1. Introduction

- 1.1 WYG has been appointed by Ingham and Yorke on behalf of their client, Mr M. Fisher and Dr G. Fisher, to provide traffic and transport advice regarding the Teewood Farm barns, Waddington proposals.

- 1.4 The site layout, including the form of access and visibility splays is shown in WYG drawing A108315-SK01-P02, provided as **Plan 2**.
- 1.5 The purpose of this Technical Note (TN) is to appraise the Local Highway Authority (LHA), Lancashire County Council (LCC), of the benefits of the new access arrangements.

Proposed Site Plan
Scale 1:200

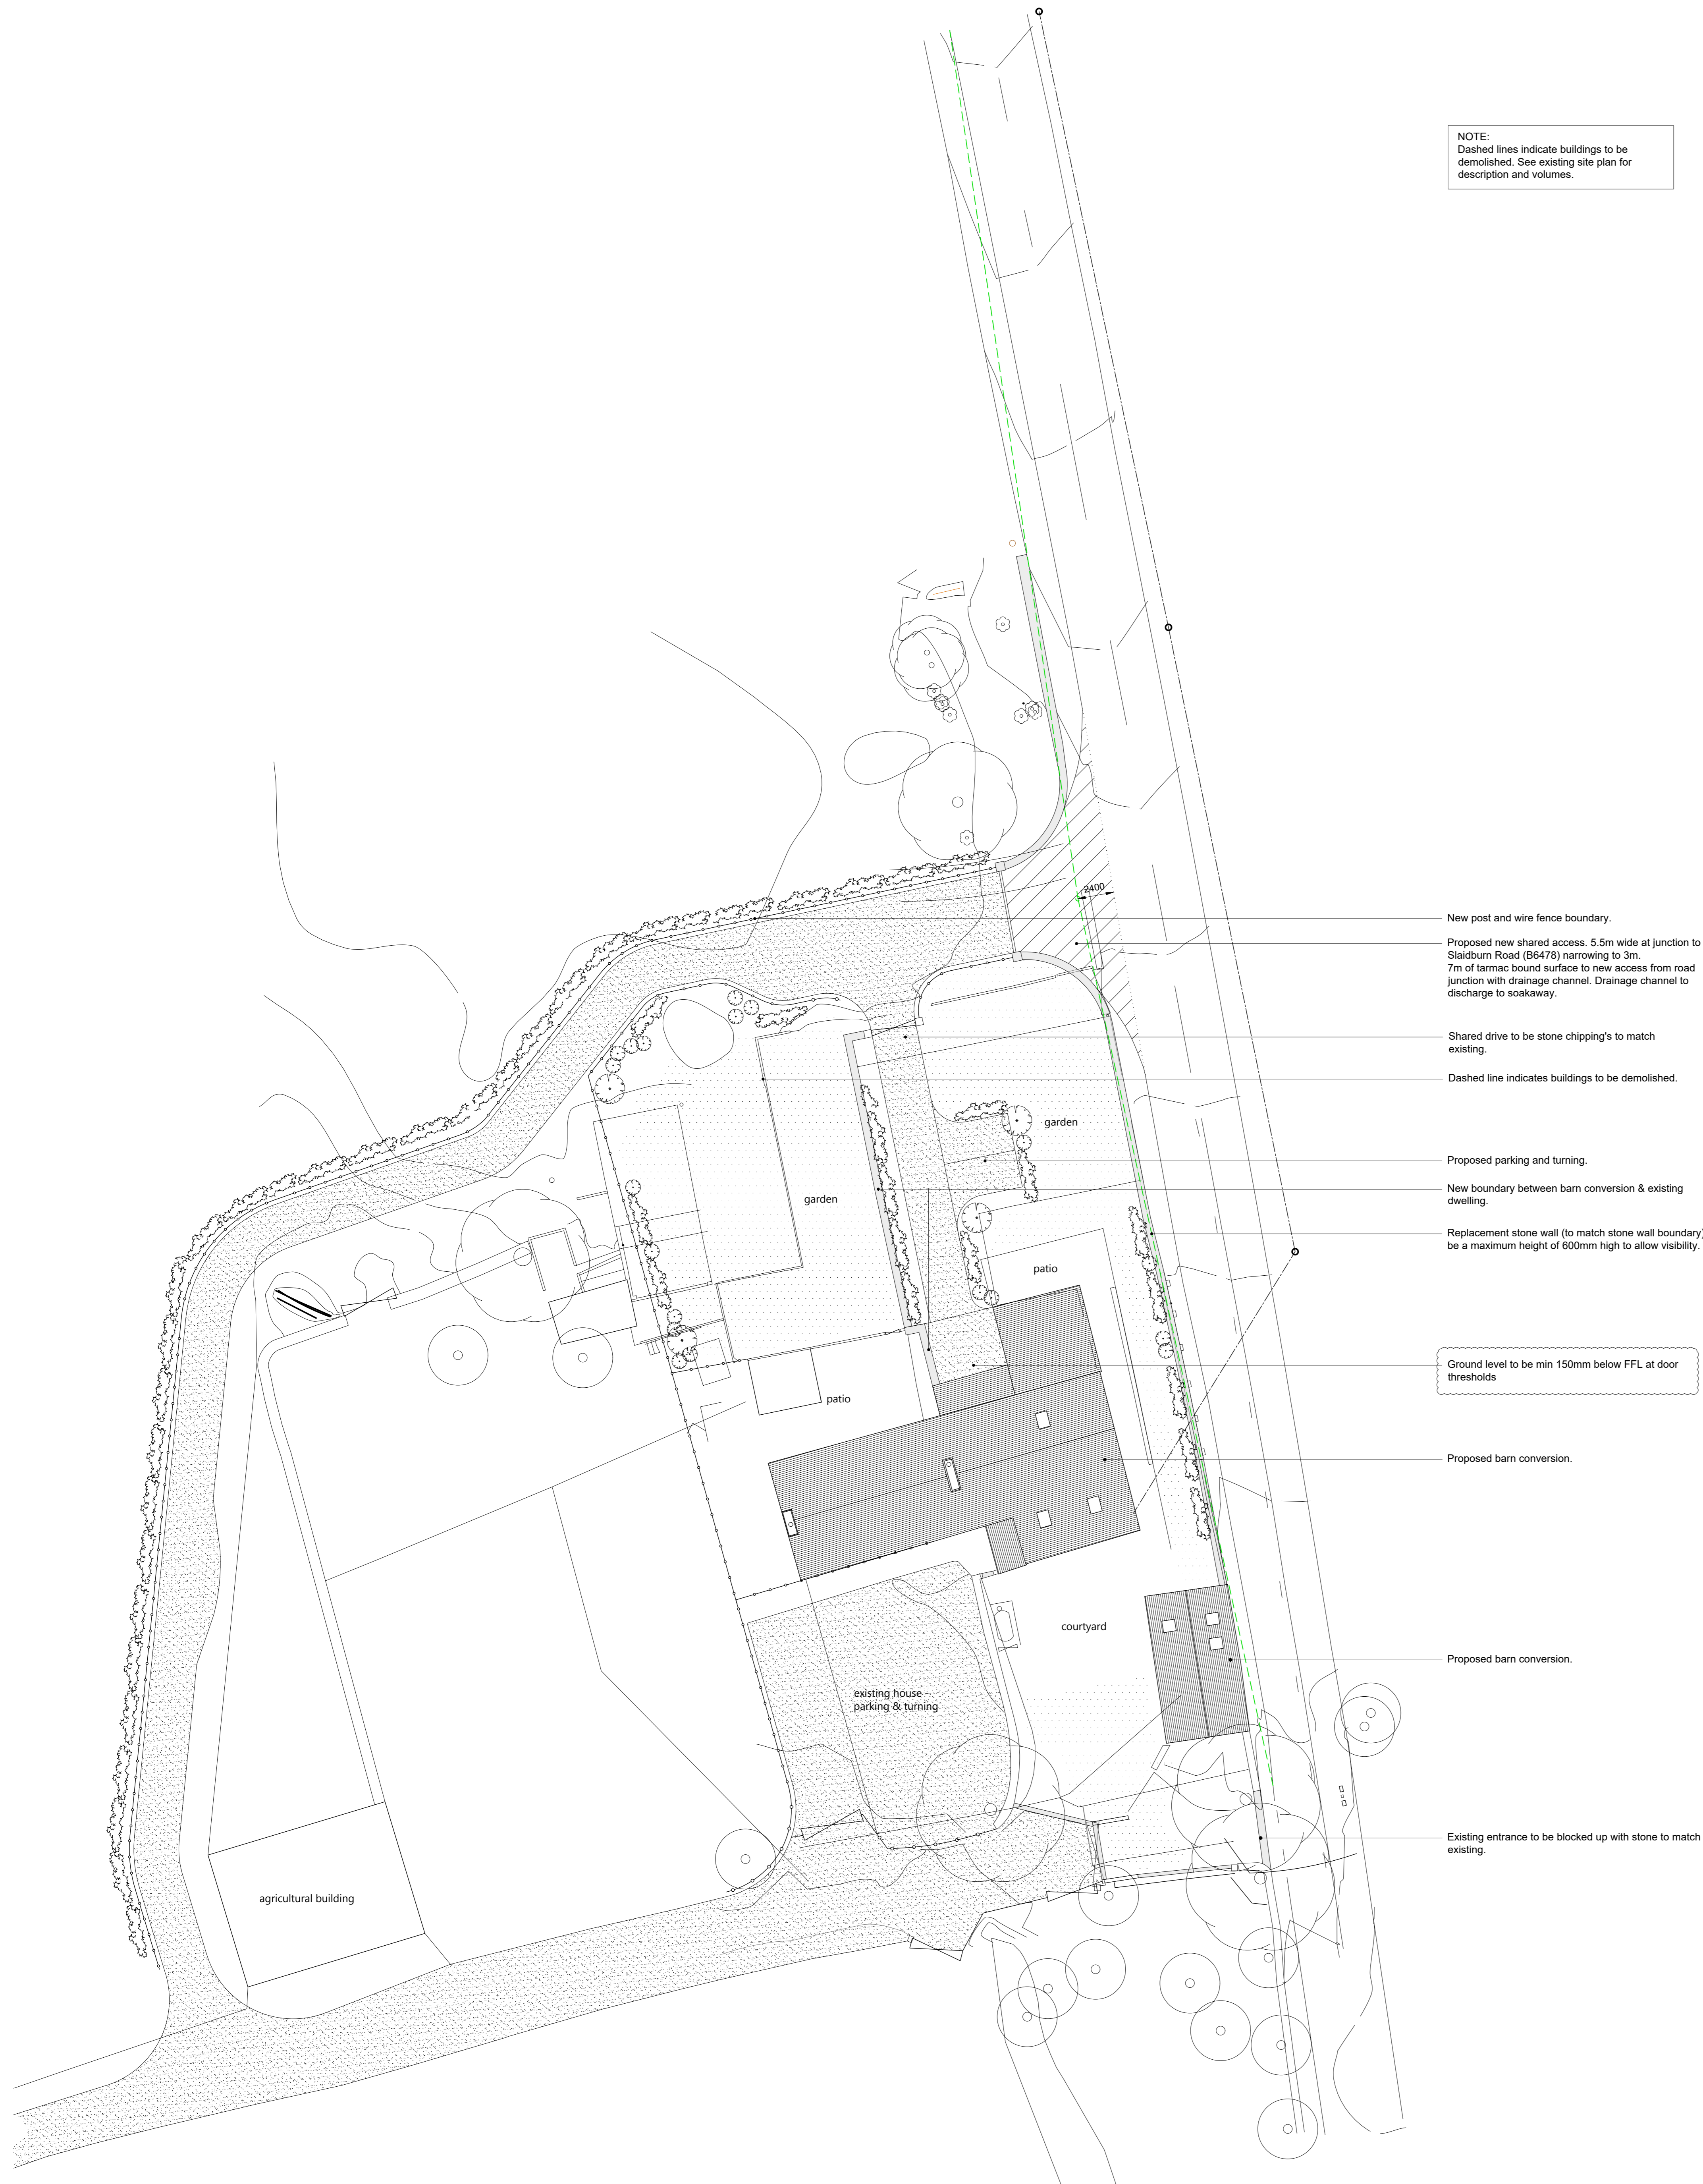
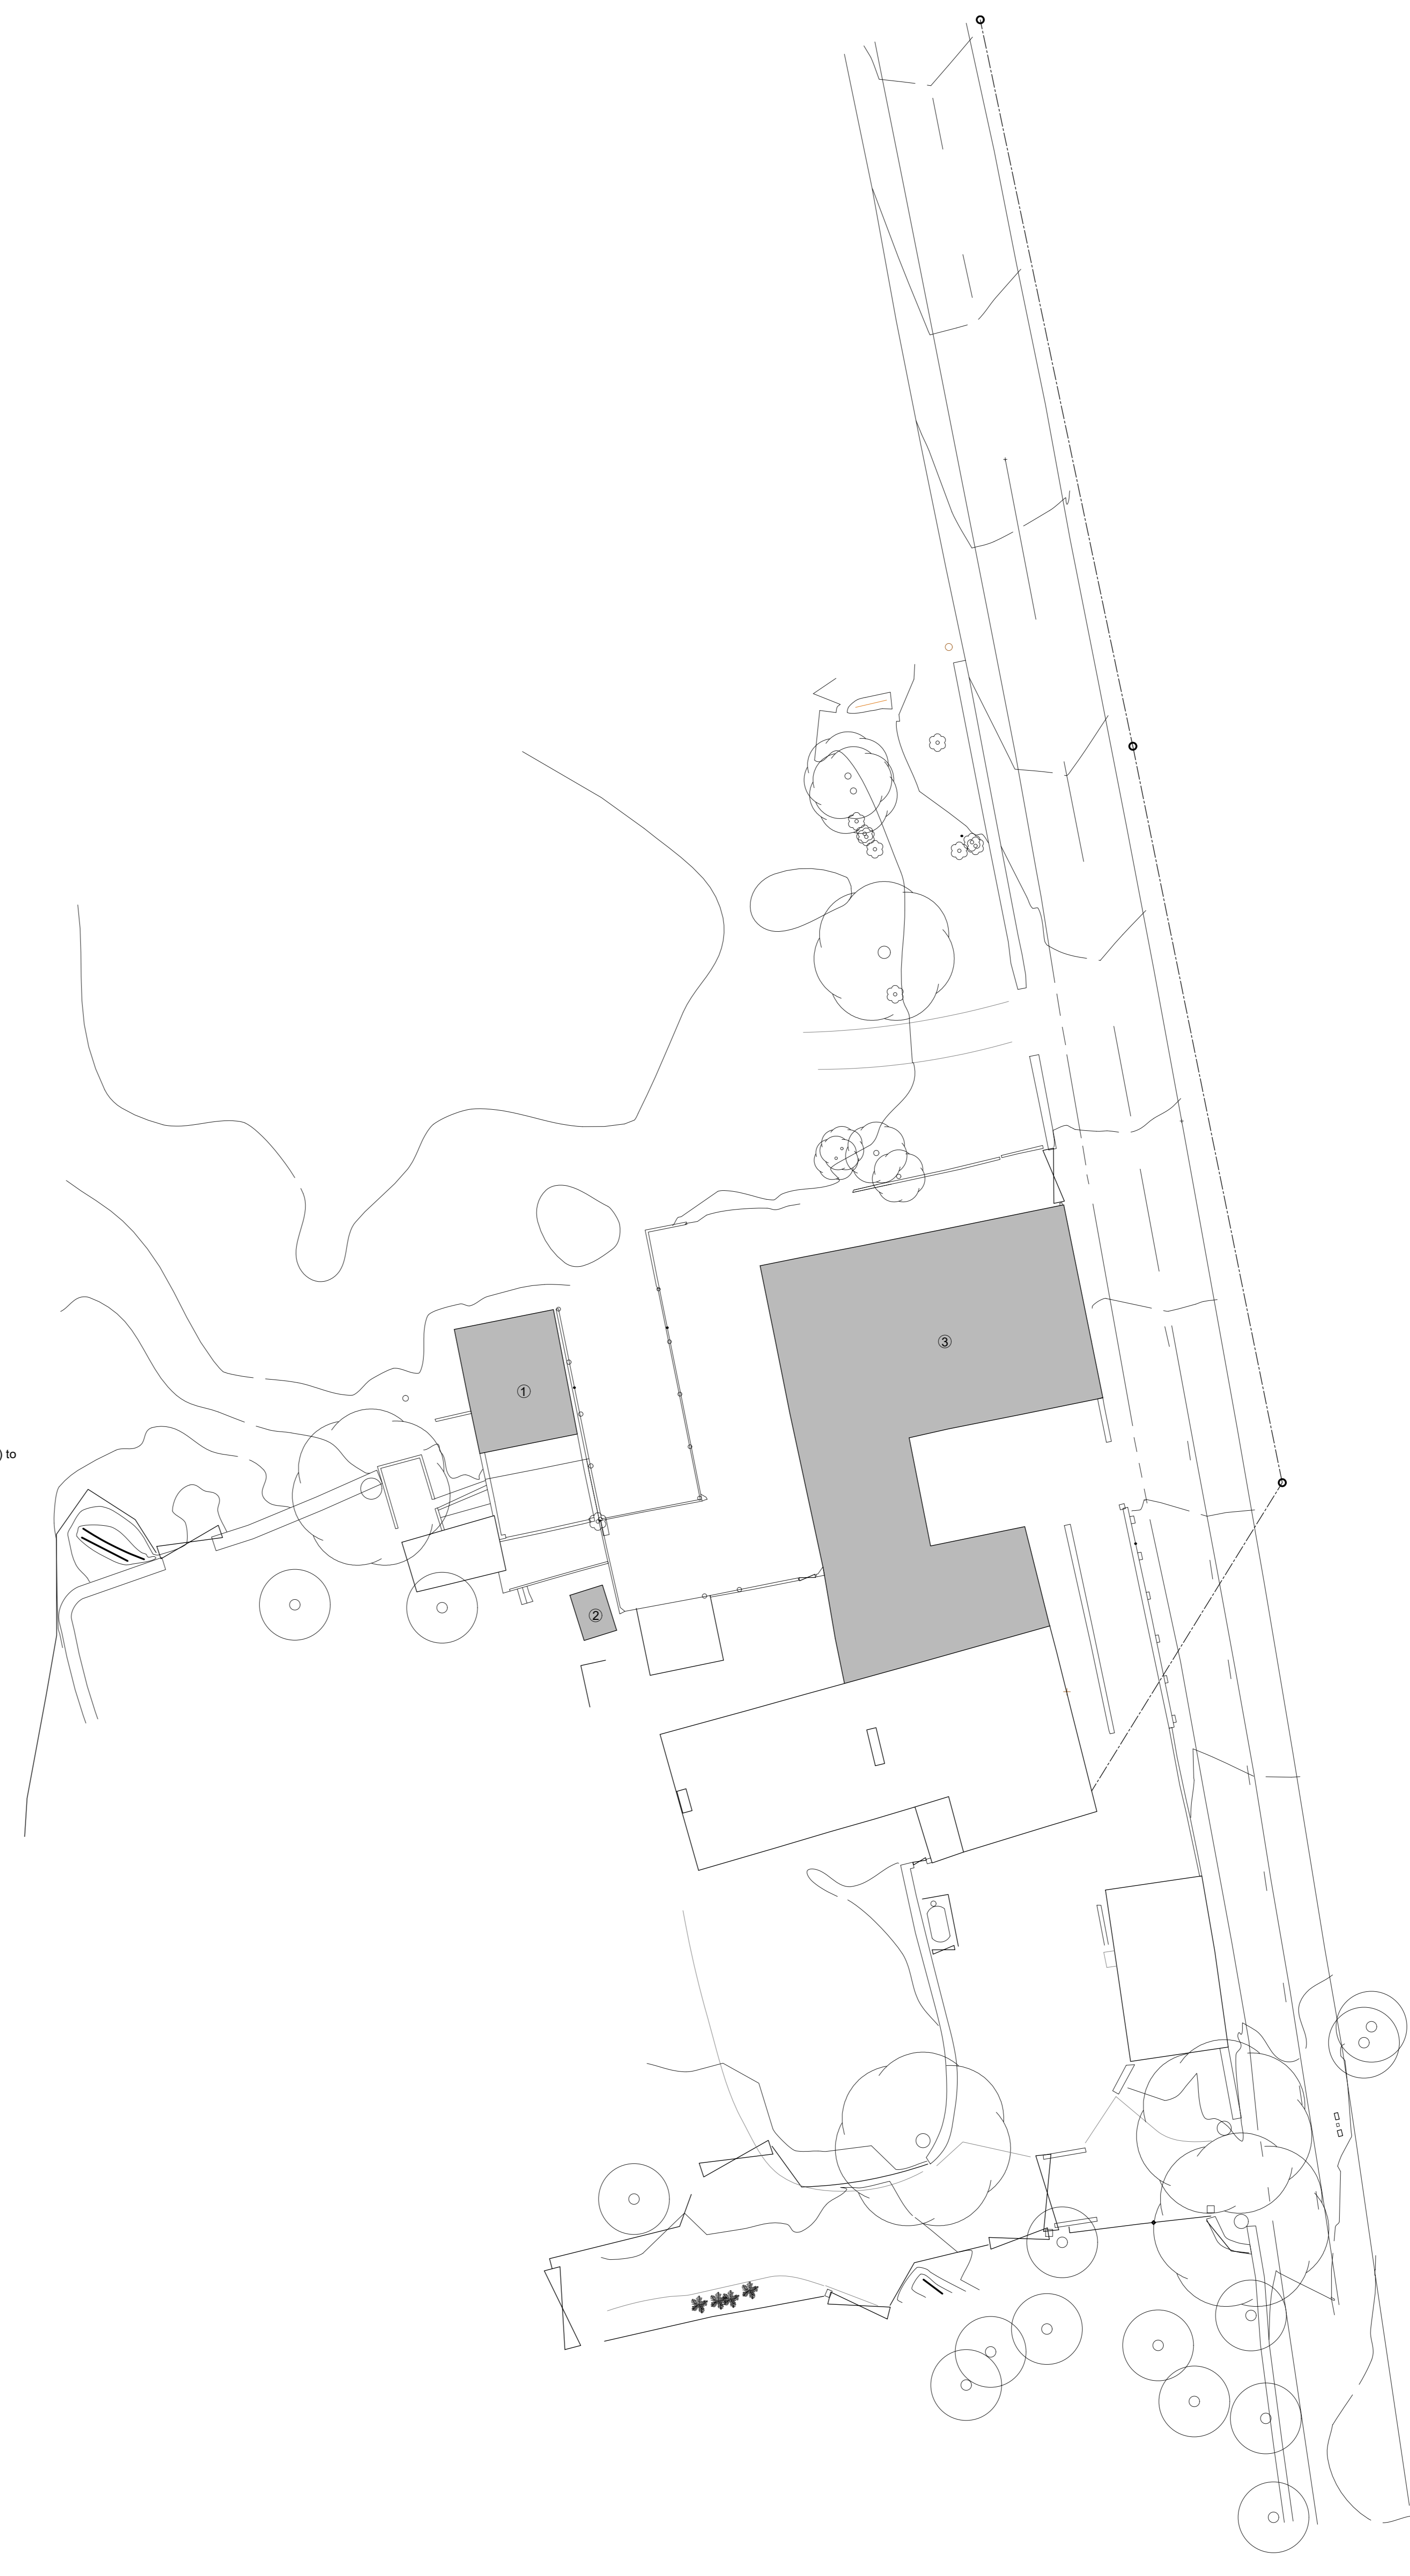
The new access would improve the visibility for the existing residential developments served from this access and as such it would be supported. As with the previous case, I would require a similar access treatment. The existing access should be permanently closed to all traffic and walled.

in the meantime can you confirm that the existing access points will be permanently closed. There is nothing on the plans to show that this is to be the case. In the case of Betty Barn , Hollin Farm share the access and their agreement will be required.

More specifically the Teewood plan shows 2 barn conversions, how is access gained to the smaller of the 2?

- 2.5 LCC provided advice on the required width and extent of surfacing of the new proposed access. It was agreed that the access will be capable of accommodating two-way traffic at the entrance. Suitable surfacing will be provided for 7m into the site at which point it will tie into a new farm track.
- 2.6 LCC also required that the existing access junction be stopped up.

NB: the existing access could be used as inbound only, but the applicant has agreed to stop it up in this case. Whilst a case could arguably be made that intensifying the existing sub-standard junction by adding one more property’s traffic would not be a material change, the applicant has instead taken the view to significantly improve the access and egress which will also benefit the existing access users, by promoting a new access proposal as illustrated on **Plan 2**.

"Re. Teewood Farm and the two barn conversions, it is proposed that the smaller of the barns will be ancillary to the main barn and therefore access and parking is via the same route."
